Notes of 2/15 MMC Site Plan Review Meeting (CMP/Detours)

Congress Street Closure and associated detours/emergency access (based on the revised docs and plans attached to this e-mail from Gorrill-Palmer)

CMP - East Tower and Visitor Garage (based on revised CMP as attached from Turners)

**MMC HOSPITAL EXPANSION  
 EAST TOWER OVERBUILD  
 STRUCTURAL STEEL  
 TRUCK ROUTE FROM I-295N TO MMC SITE ON  
 WESCOTT STREET  
 1-295 N TO WASHINGTON AVE. TO CONGRESS  
 STREET TO ELLSWORTH STREET TO  
 WESCOTT STREET SITE**

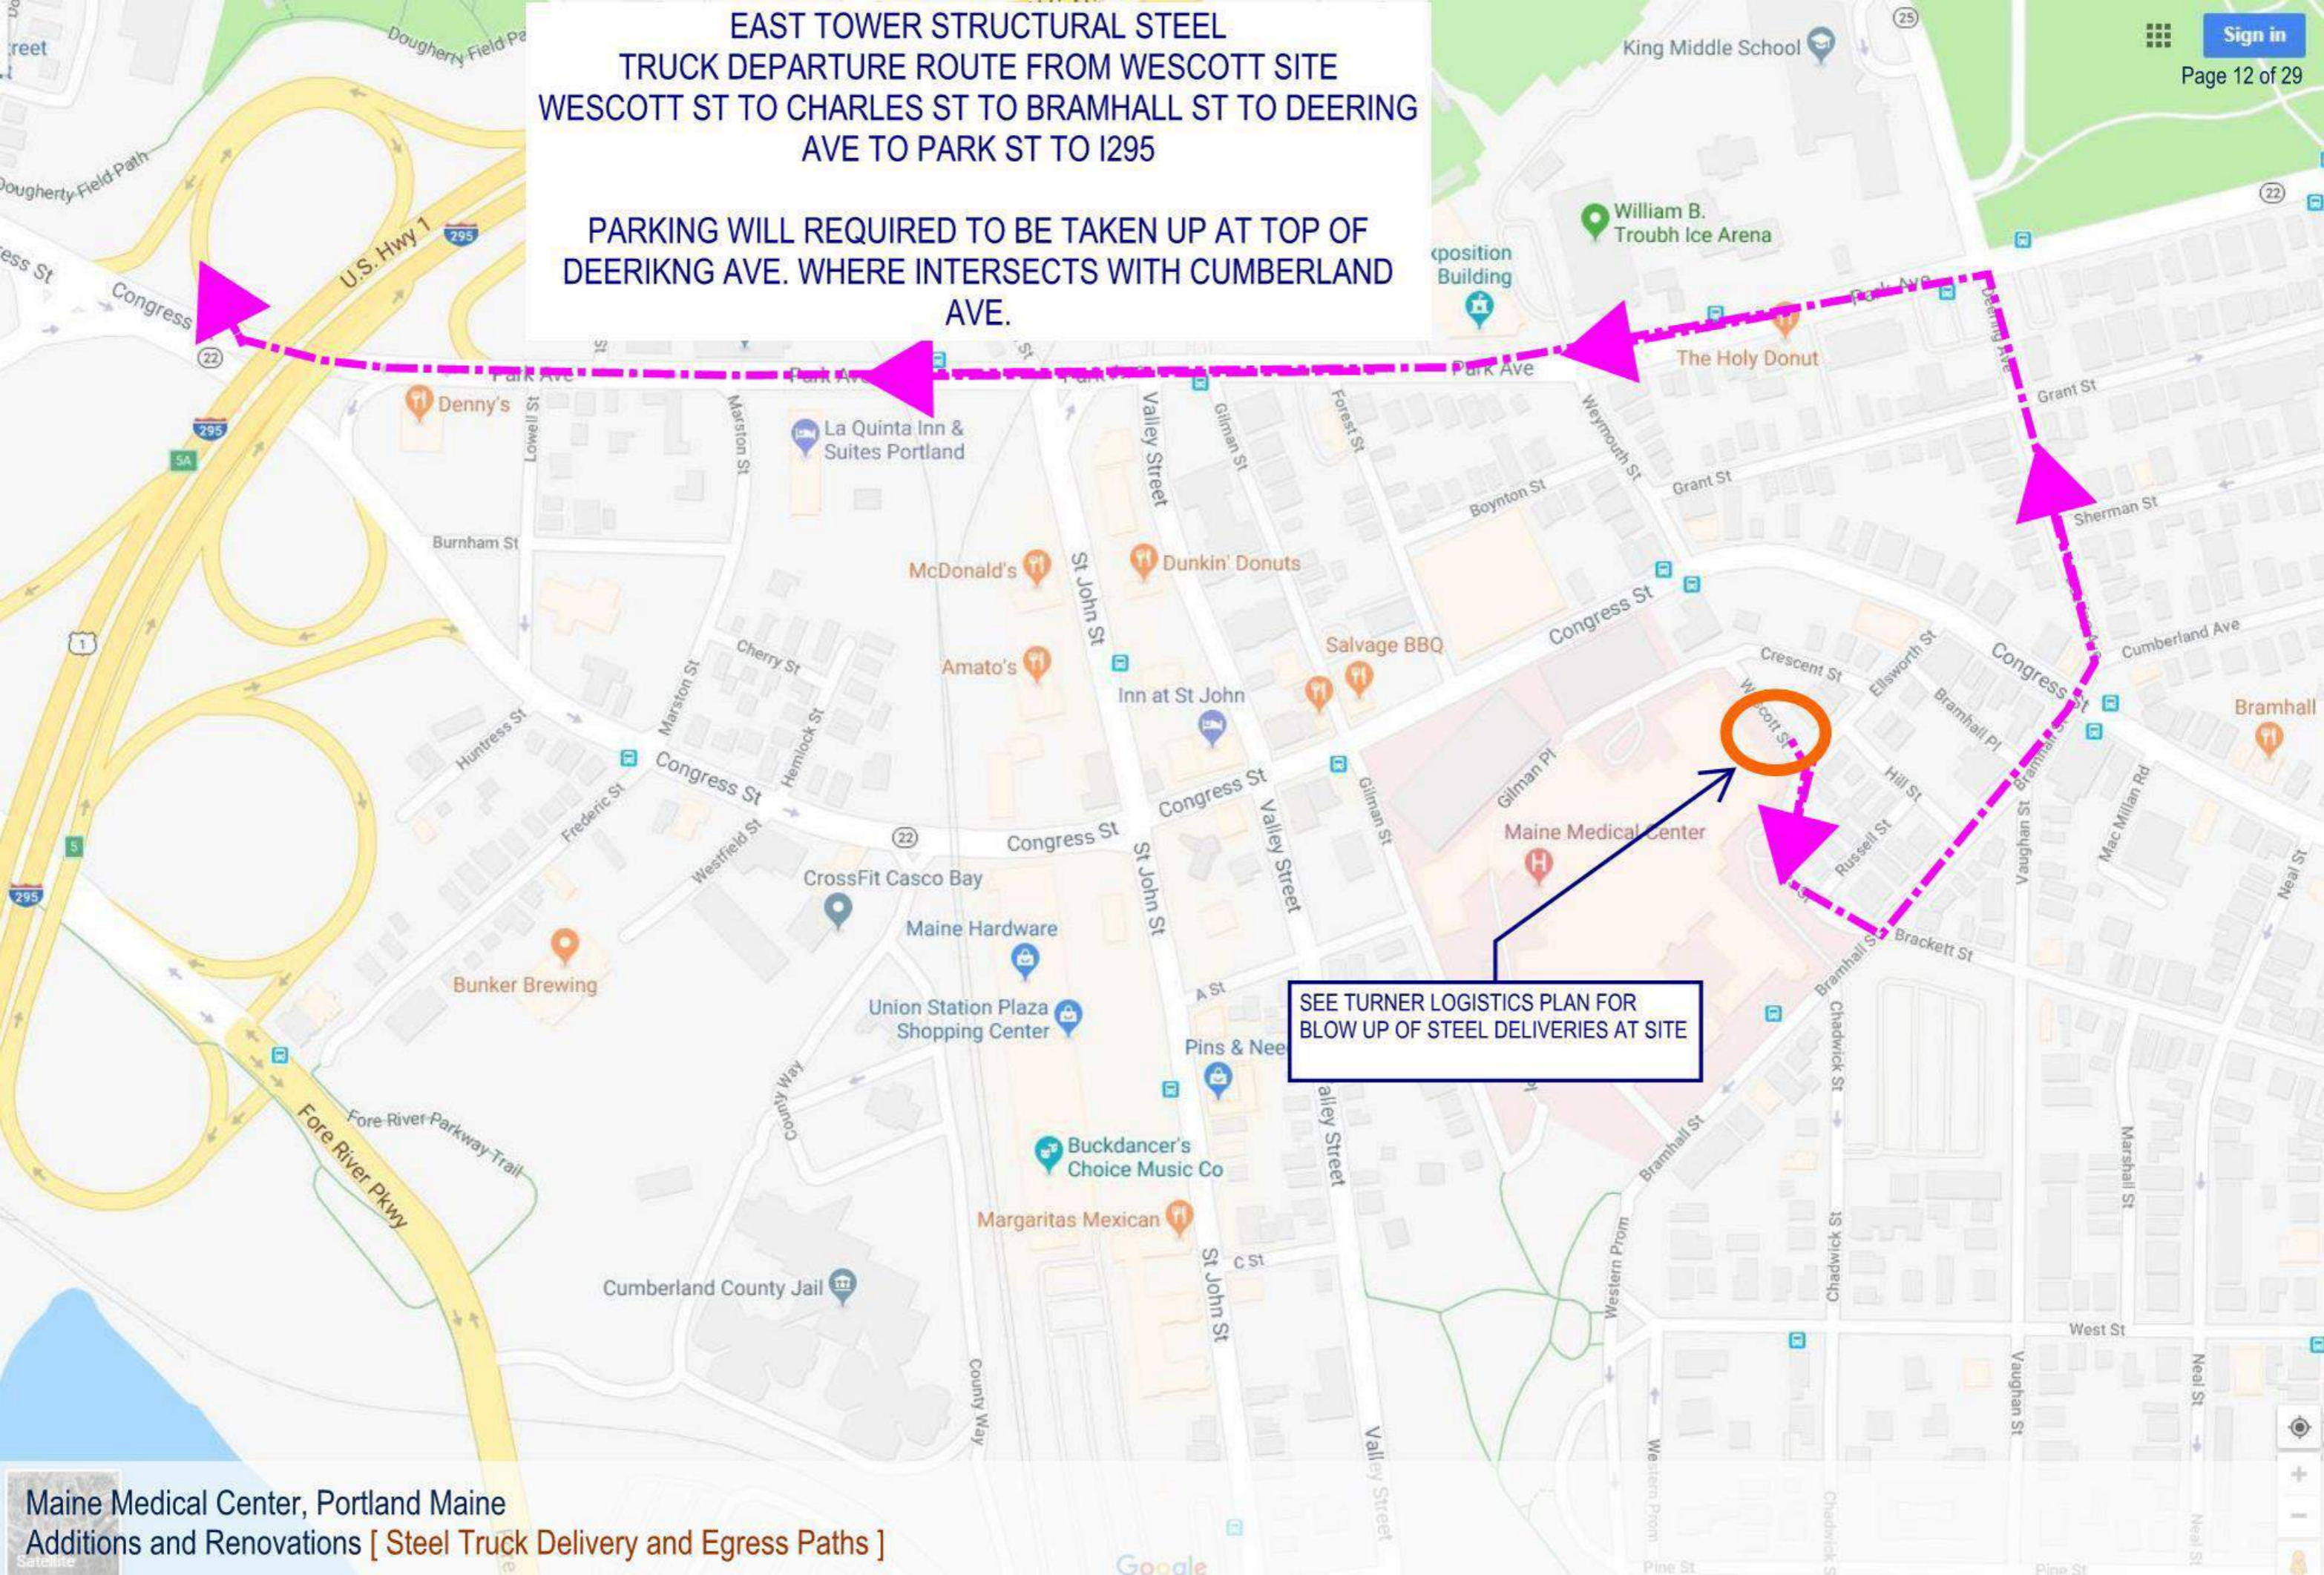
- Reviewers questioned the proposal to route steel deliveries (from North, June 4 to June 28, starting at 5am) along Washington Ave and Congress
 - City staff advised route should avoid Washington completely due to planned construction work

- Route must avoid downtown Portland and Congress
 - Keep delivery vehicles on I295 longer - maybe I295 to Forest /Park ? Deering; maybe Fore River Parkway

- Turners will speak to the trucking company again and get back to us
- Police stressed need for ongoing monitoring and process for making changes to delivery and detour routes after closure starts

NO VEHICULAR TRAFFIC ON THIS PORTION OF CONGRESS STREET

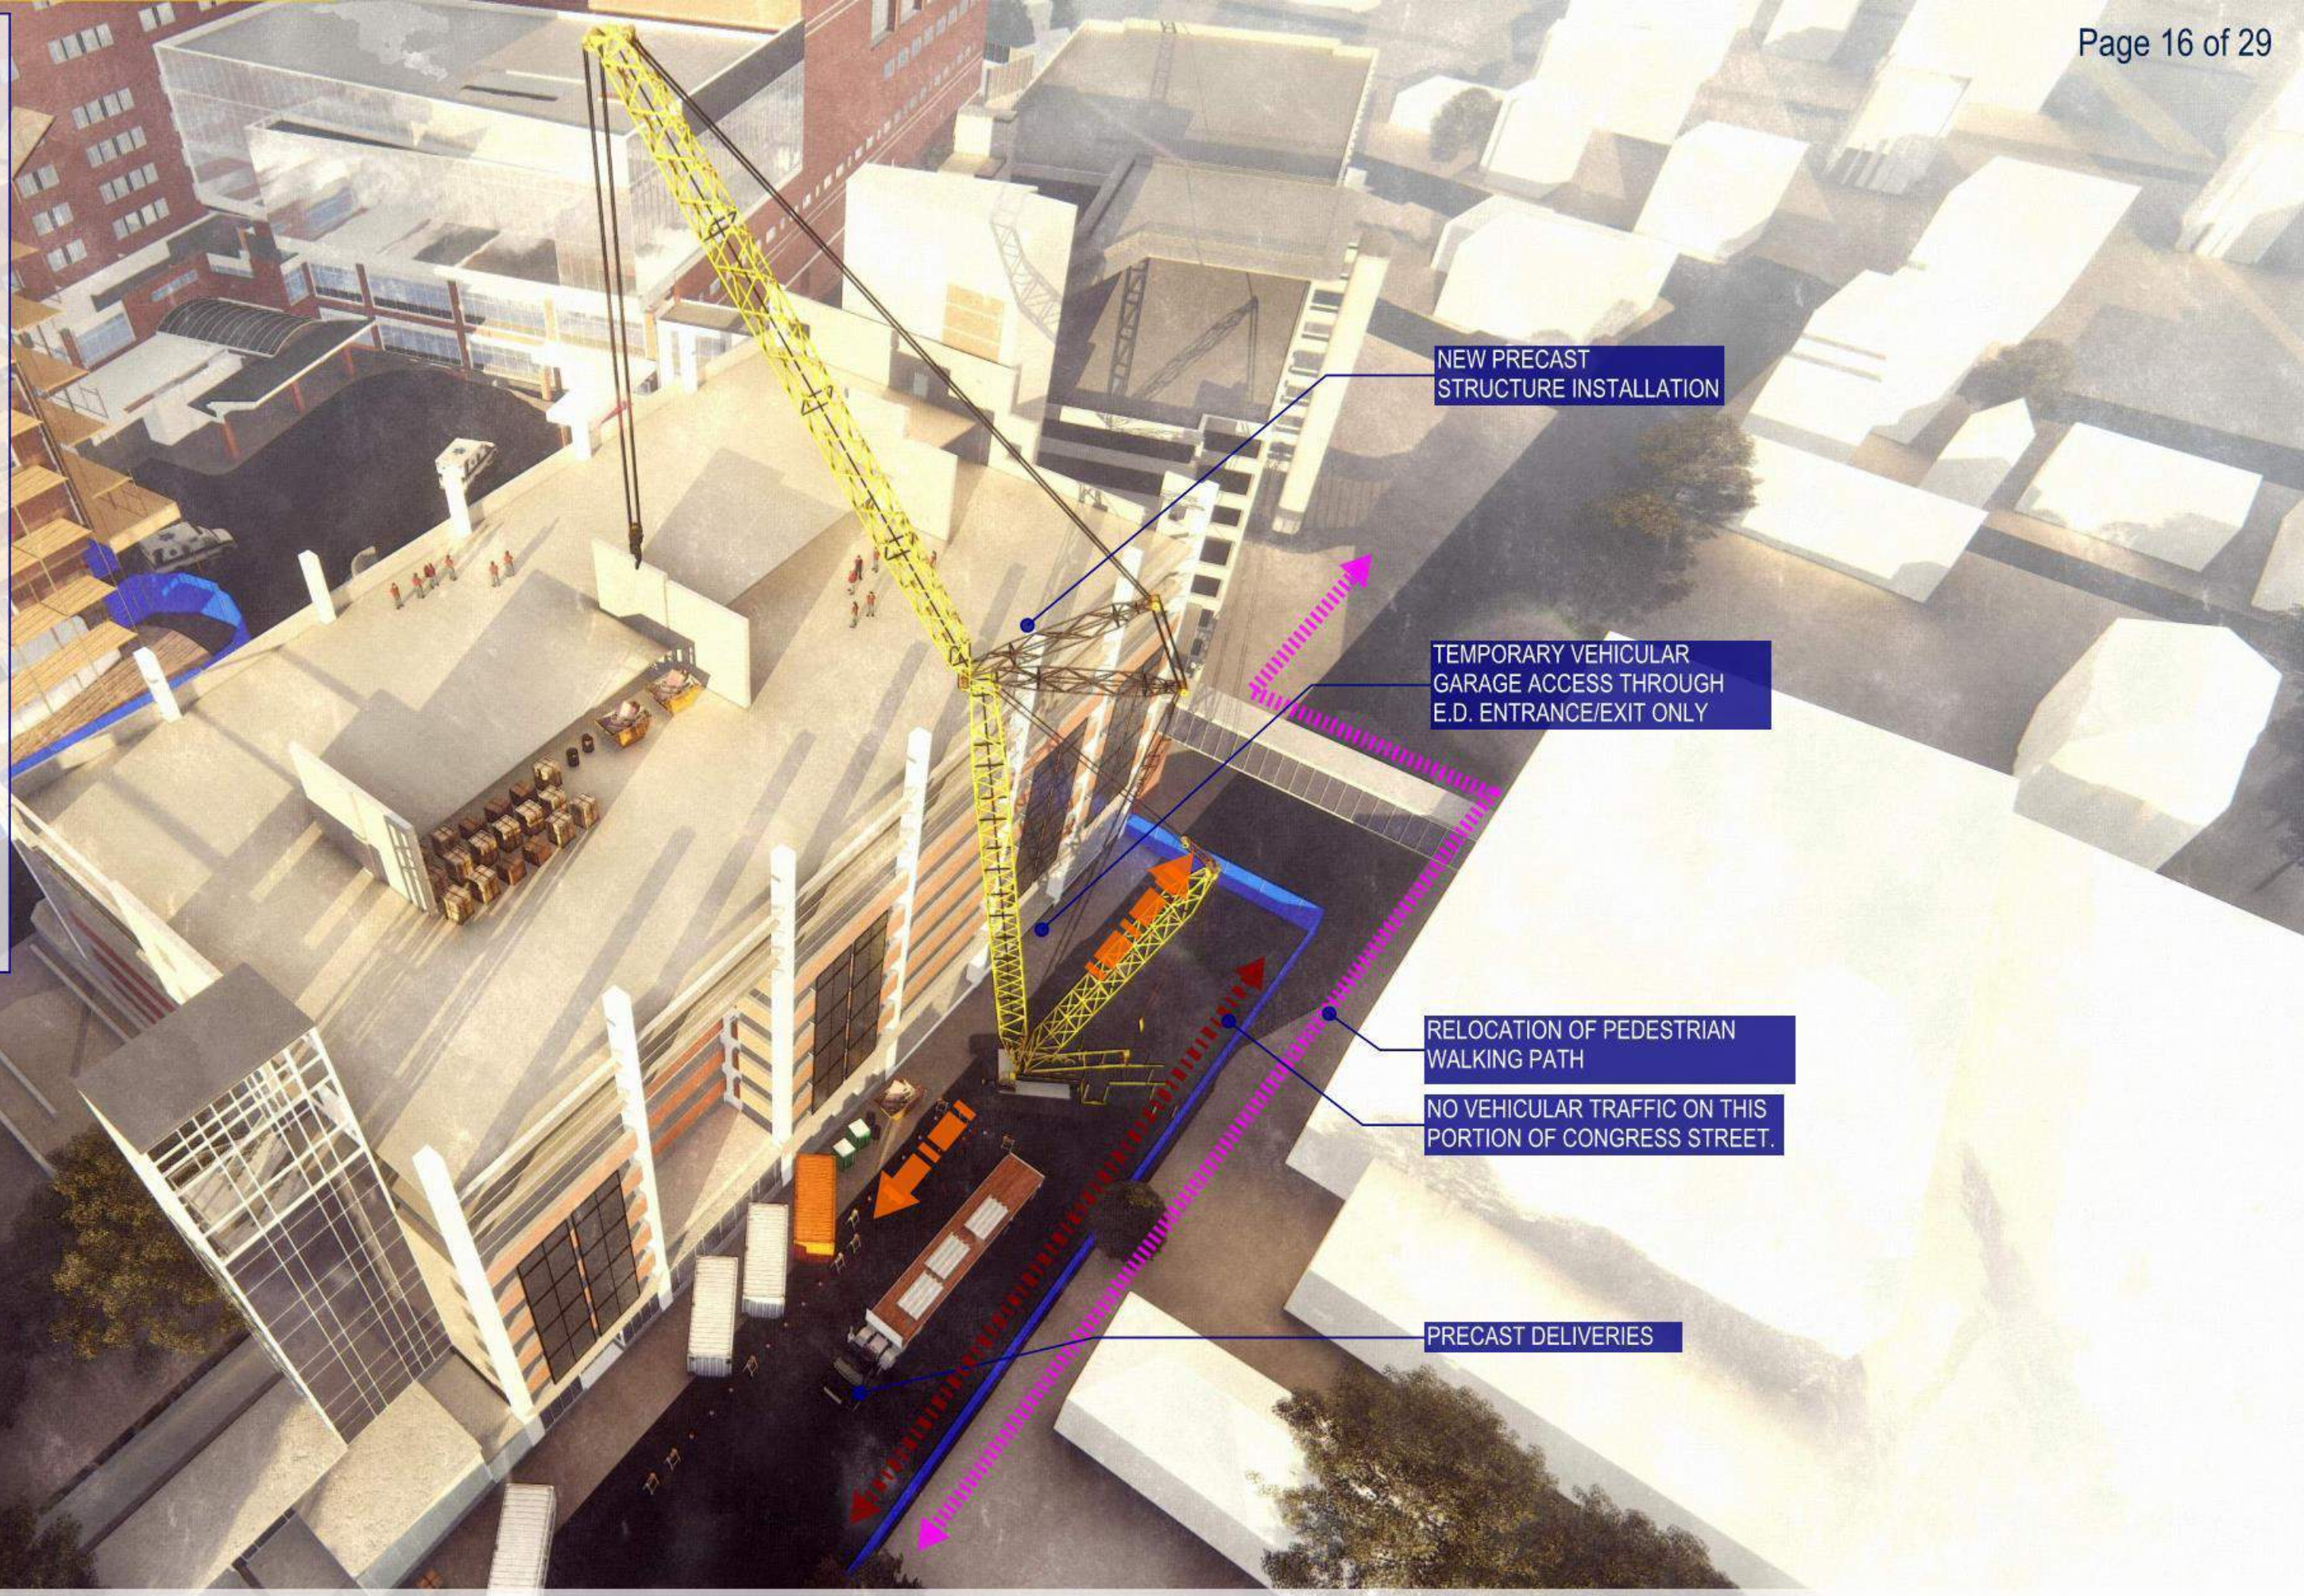
- Congress St closure anticipated May 7 to June 28 for the installation of precast beams for overbuild of the visitors garage - weather biggest factor
- Turner summarized the revisions to CMP, which included facilitating the ambulance access, adding delivery routes

- Concern re pedestrian route along Congress by construction area
 - Need ADA ramp
 - Need 9ft for crossing
 - Ensure entire sidewalk available

Maine Medical Center - Garage Access During Congress Street Closure

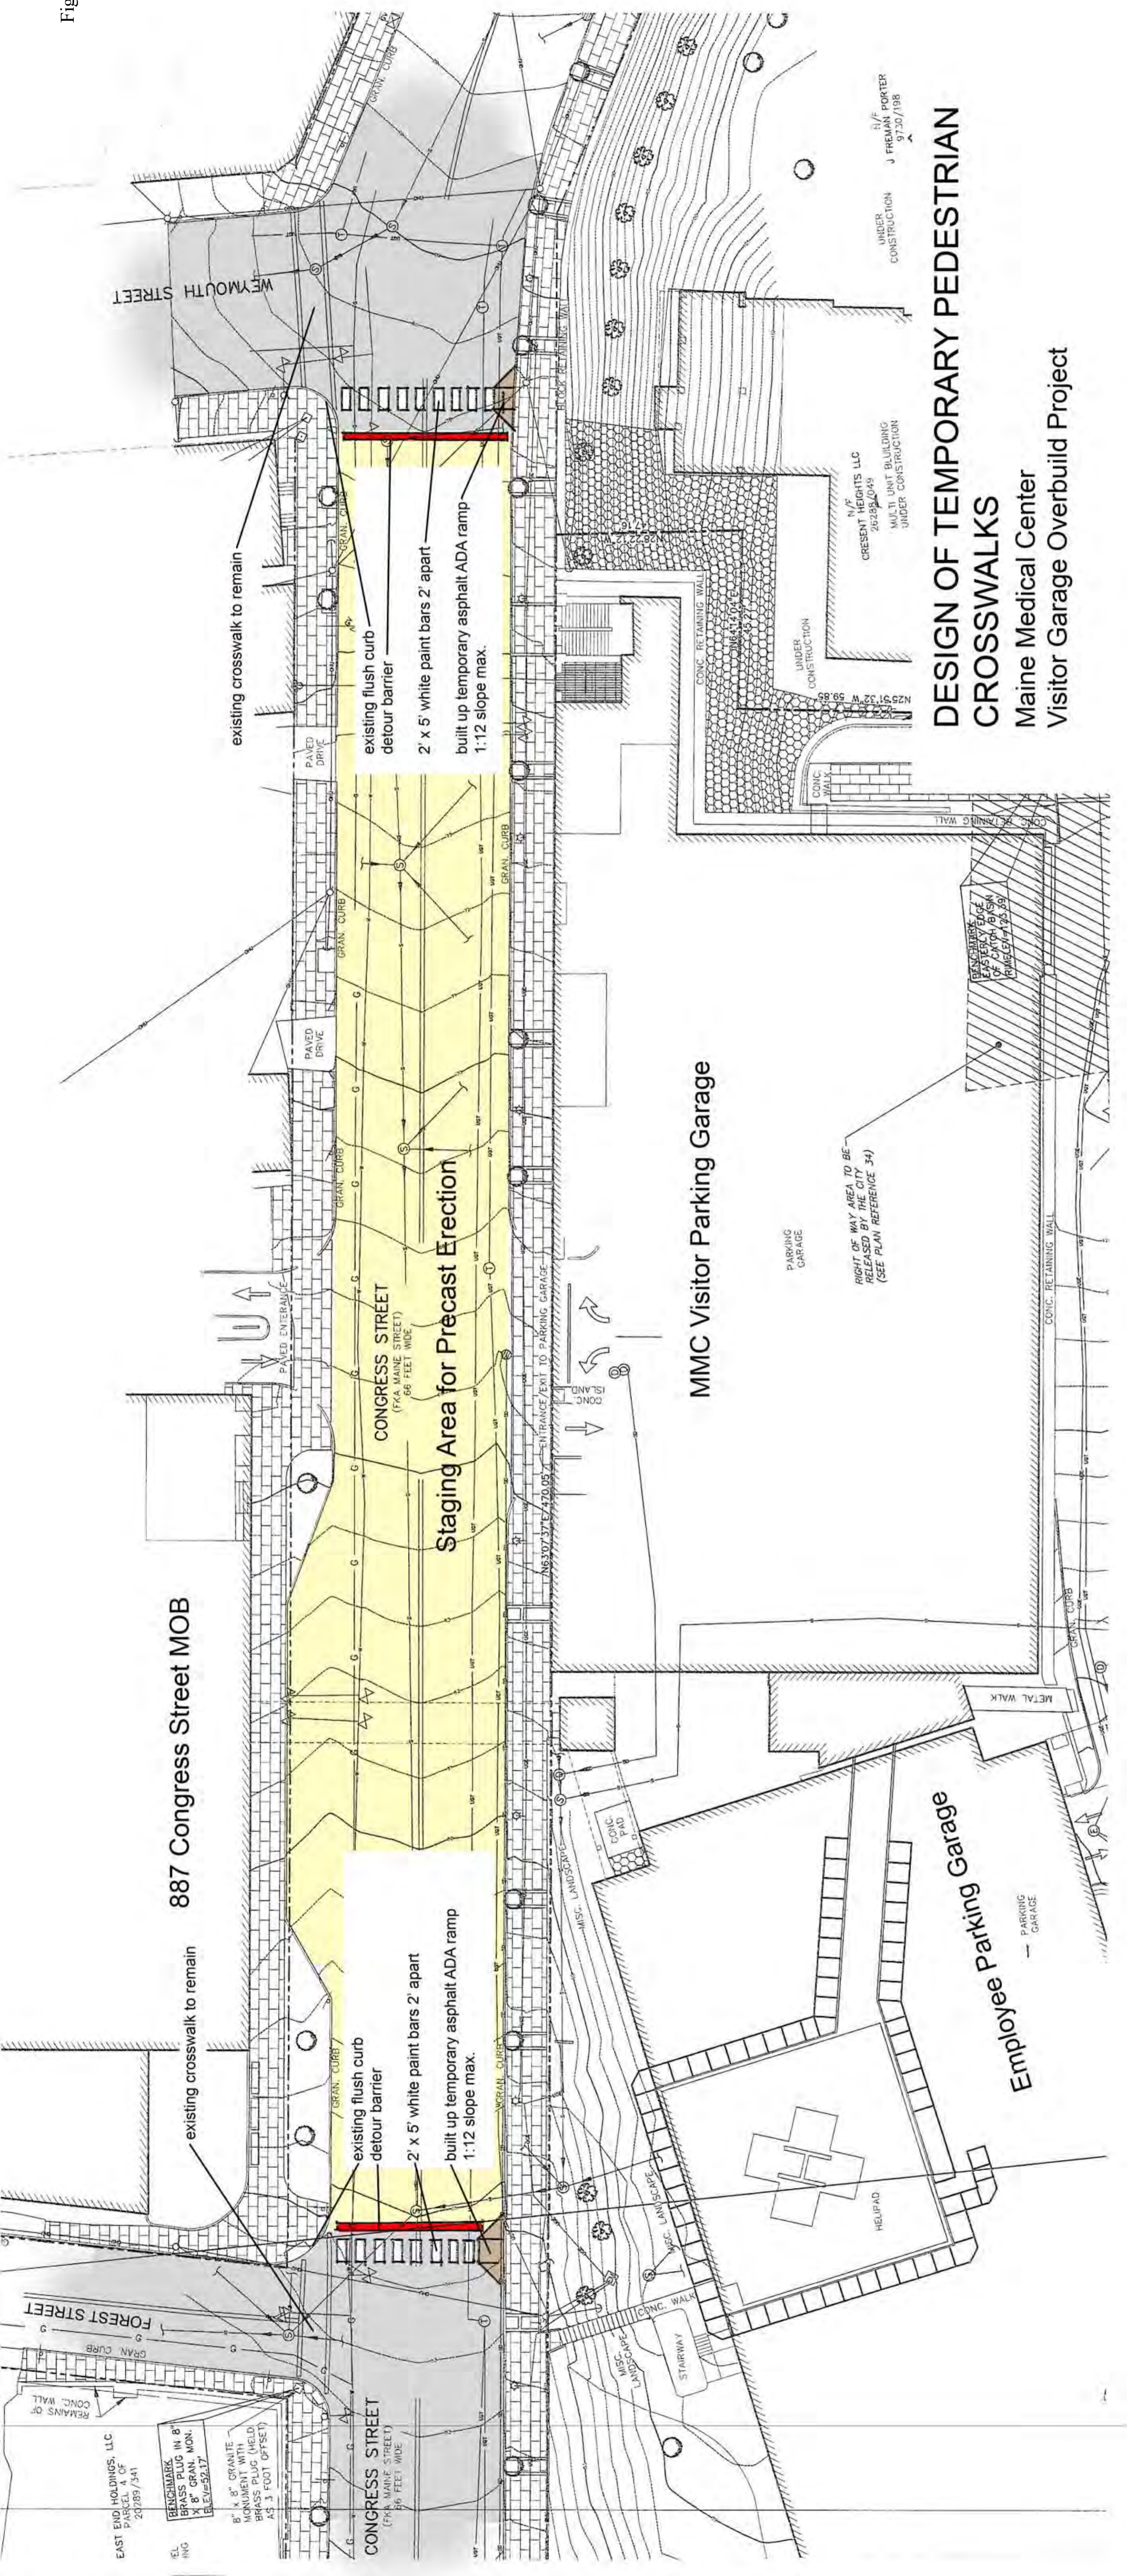
- Consider impacts on residents and businesses of some routes and semi-closures
 - Introduce Boynton as one-way working a couple of weeks in advance
- Access to visitors garage during Congress closure (see plan)

- Via employee garage, channeled and flaggers as needed
 - 200 employees moving out of the employee garage to make up for loss of 2 levels in visitor garage during construction
